**Letter of objection to the Preferred Infrastructure Report for State significant infrastructure application SSI-9487 Inland Rail – Narromine to Narrabri**

1. We act for NSW Farmers in relation to the Narromine to Narrabri Project part of the Inland Rail Project (**N2N Project**) which is the subject of State significant infrastructure application SSI-9487 (**N2N SSI**).

NARROMINE TO NARRABRI QDL departures - Scour / Erosion - 1% AEP with blockage – Reference Design Appendix I - Figure 2.4.3

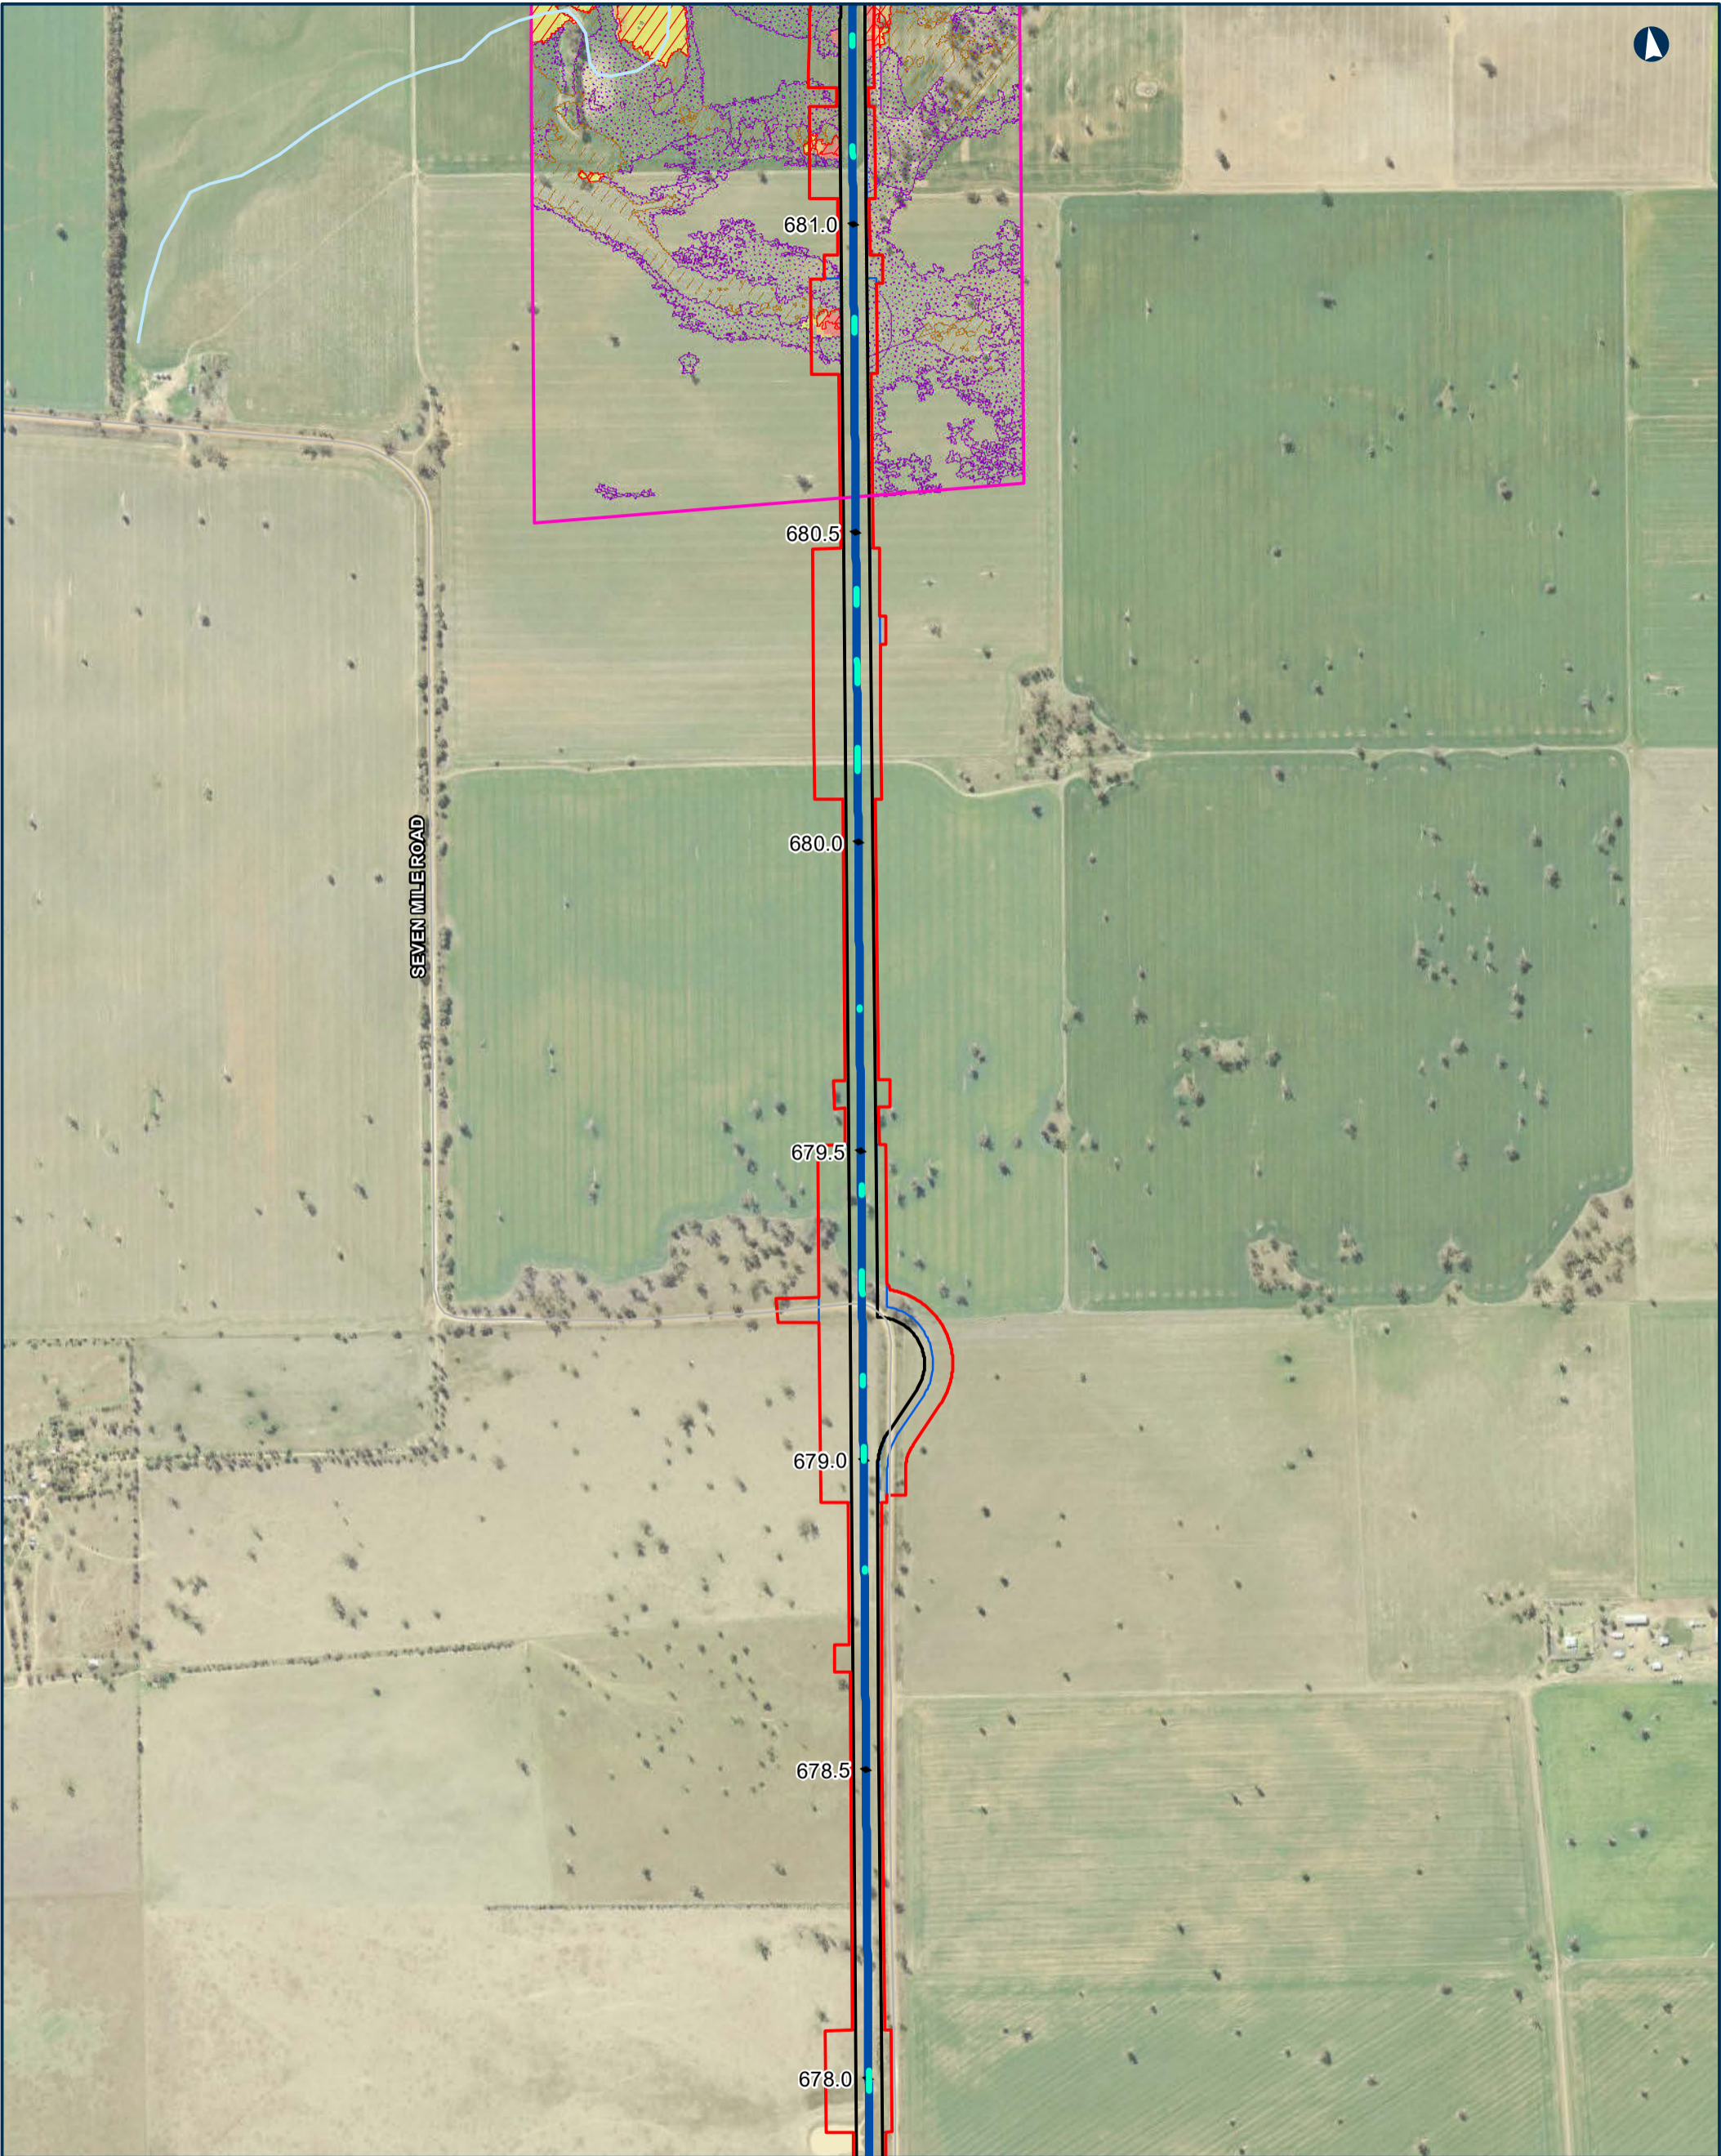
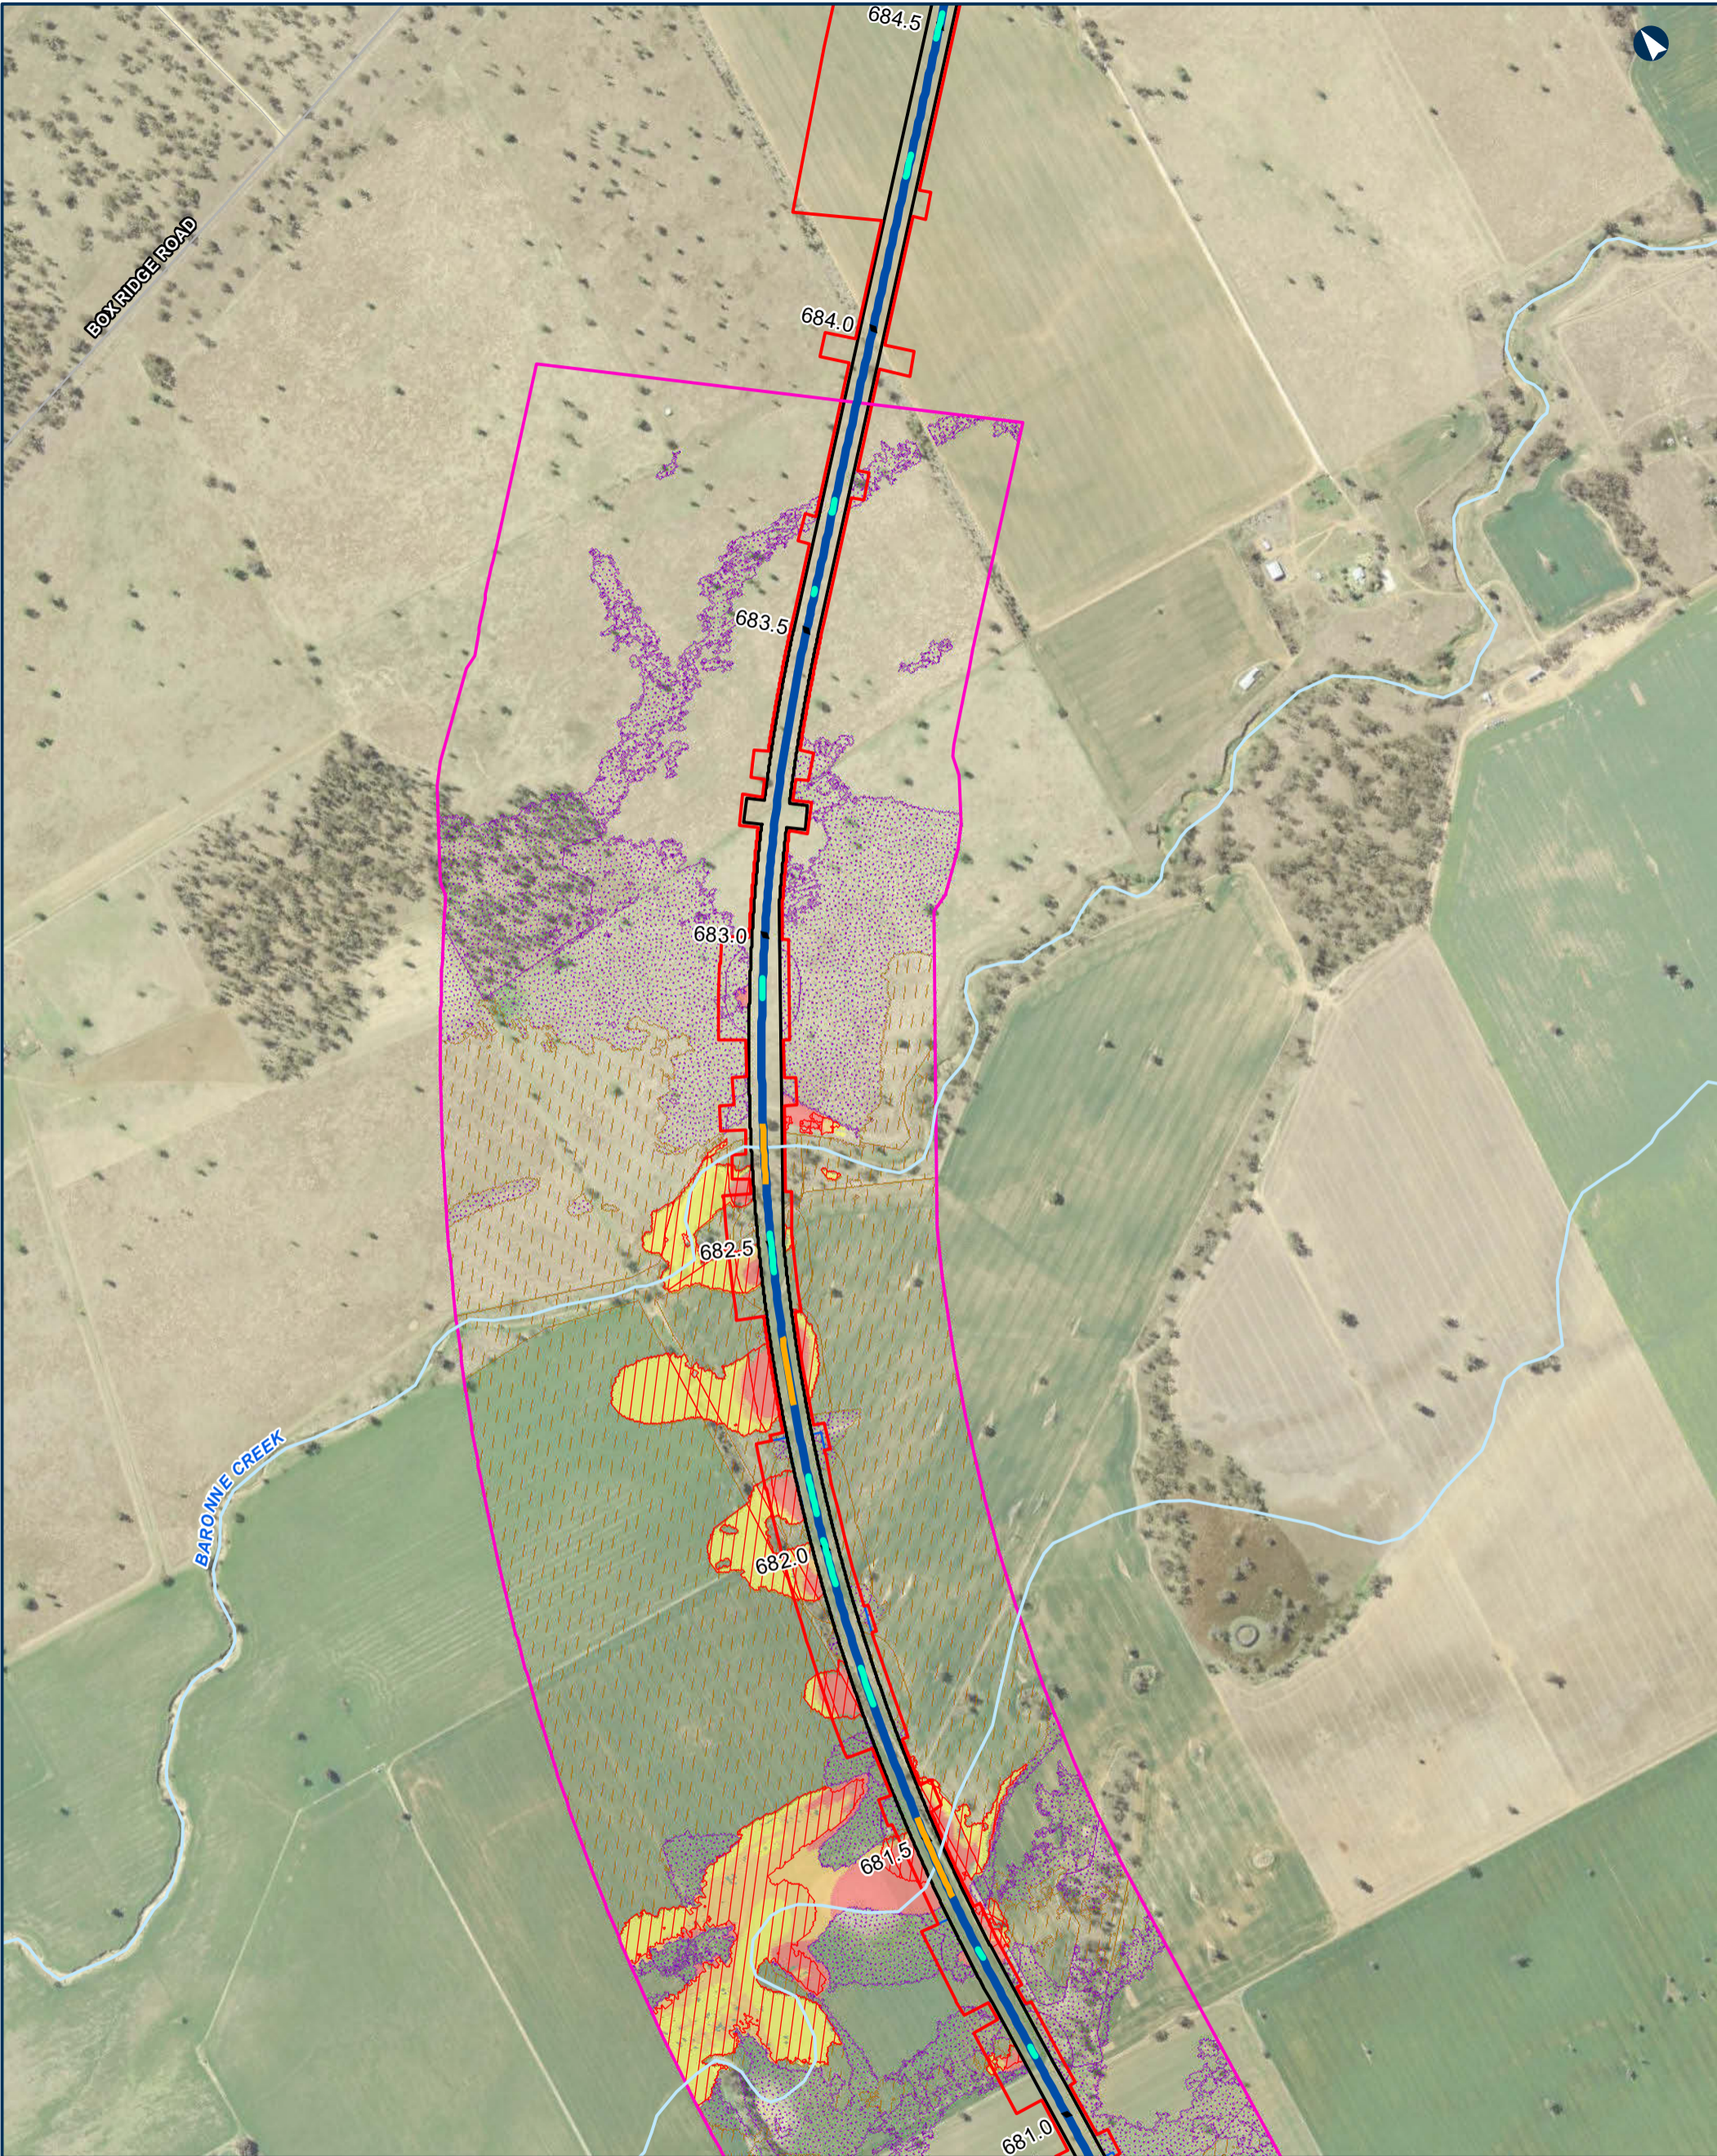
- 22.2 Concerns also remain about the impact of the construction of the rail line in the area of the **Warrumbungles Watershed**. Some identification of quantitative design limits (QDLs) to ensure that velocities do not exceed the speed where water could potentially cause scouring but without detailed design there are still concern that even if the velocities can be managed within acceptable parameters fundamentally those structures are converting sheet flows into channel flow and changes to the nature of flows beyond land owned by ARTC cannot be authorised without an easement granted by the landowner.
